REPORT UPON APPEAL OF CATIR BROS. RELATING TO
BUILDING AT 284 CONGRESS STREET.

Catir Bros. desire to remodel the building at 284 Congress Street which was formerly used for a combined tenement and lodging house so as to make of it a six family tenement house. This is a wooden building for the most part two stories with french roof, making it substantially a three story building. They propose to make the sloping part of this french roof plumb and to raise the roof of the two story ell and to build a three story portion to fill a present jog so as to make the building uniformly three stories high. This question involves the Building Ordinance only.

Referring to your application in the name of Catir Brothers for a building permit to cover changes in the building at 264 Congress Street to make of it a 6 family tenement house, there are the following criticisms:

APPEAL OF CATIE BROS  
284 CONGRESS ST  
Scale: 1" = 20' - PL 416

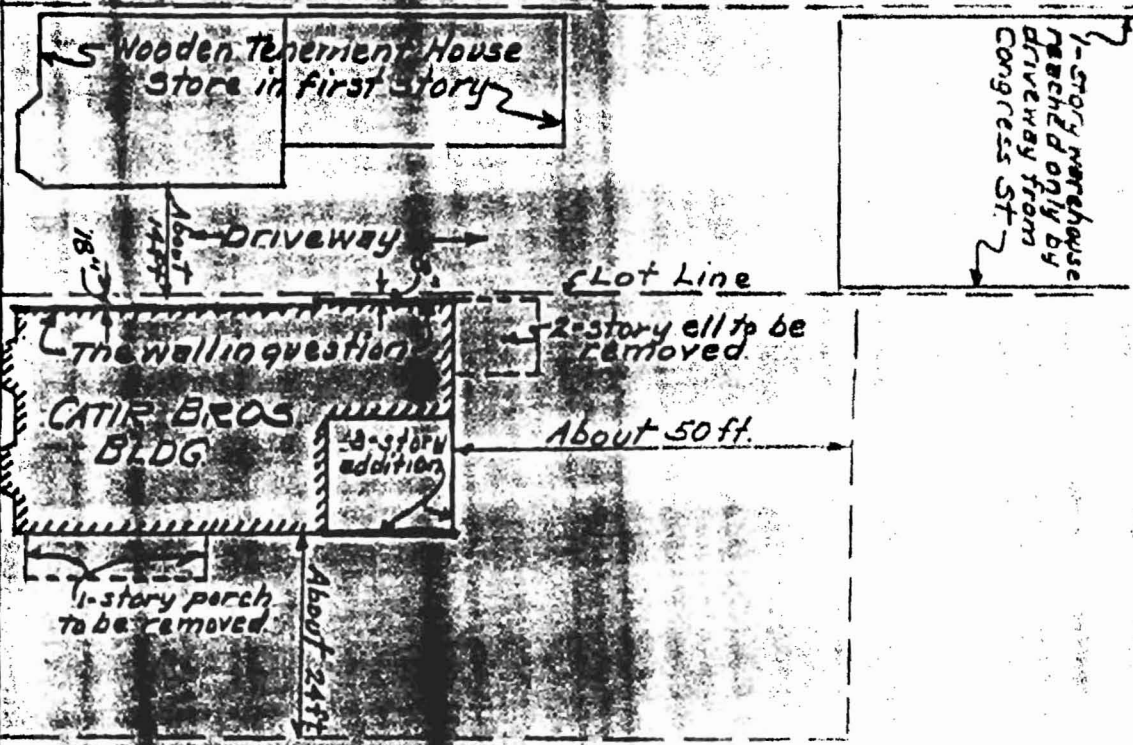
The Building Ordinance requires certain window areas for lighting and ventilating rooms in tenement houses and in the process of alteration the appellants desire to cut in certain new windows and use present existing windows in the easterly wall of their building to light and ventilate the rooms. The Building Ordinance requires that such required windows shall open upon land of a definite width controlled by the owner. The front part of this easterly wall is eighteen inches from the lot line and the back part is approximately eight inches from the lot line. In this case the Ordinance requires that these windows open on a width of land controlled by the owner of about four feet. For this reason the permit was denied.

The appellants contend there is a driveway upon his neighbor's land abutting this lot line which is the only means of access to a sizable storage warehouse recently built on the rear of neighboring property and that there is little possibility of the aspect of this neighboring property being changed in such a way as to deprive them from borrowing light and air from this neighbor indefinitely.

Recommended that the appeal be sustained and the permit granted.
